**SUBJECT: BRES2401-0067**  
**BUILDING RESIDENTIAL**

Here are the results of all Inspections located at **50 OTTO RD:**

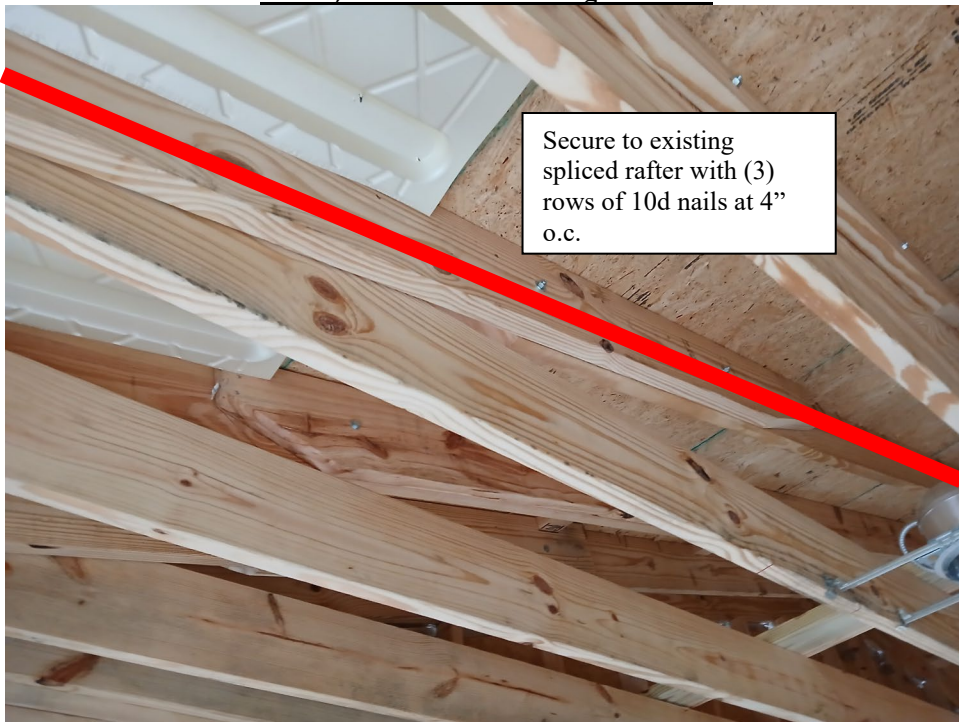
Inspection Type: ROUGH IN REINSPECT  
Scheduled Date/Time: 3/19/2024  
Completed Date/Time: 3/19/2024  
Inspector: John B Kokoszka  
Result: DISAPPROVED  
Remarks:  
Notes: 1. Missing LVL per plans with two column studs on each side  
2. All electrical needs to be tied together grounds  
3. Need to fire stop house  
4. Missing baffles  
5. Front window need that king on each side  
6. Need to see all holes to the outside  
7. Missing hurricane clips  
8. Rafters been spliced at the ends the letter  
9. Missing nail non floor joist hanger at middle pier  
10. Floor joist are not 12" on center per plans  
11. Missing 2x10 girder only has two  
12. Non treated wood can't be in contact with masonry in crawl
